DECISION DELEGATED TO DEVELOPMENT MANAGER

Application No: H02-0706-20 **Applicant:** Longhurst Group

Proposal: Details of boundary treatment, management plan for public open space and landscape management and maintenance schedules (Conditions 6, 13 and 14 of H02-0723-16)

Location: Land East Of Crease Drove Crowland

Sheet title: Boundary Treatment Plan (41 units)

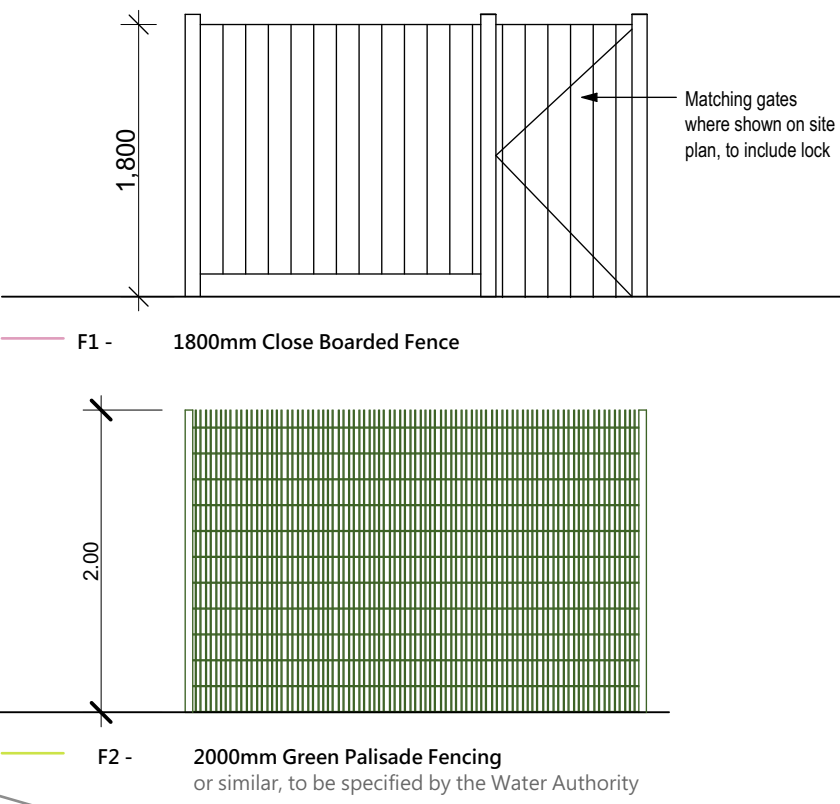
Condition 6 (Boundary treatment) - The proposed scheme of boundary treatment in so far as it relates to the 41 dwellings allowed at appeal - application ref. H02-0723-16 - remains the same as considered as part of reserved matters application H02-0079-20. When considered in the context of the submitted levels details (H02-0710-20 and H02-0708-20) there are no material concerns that would justify a need to depart from that proposed.
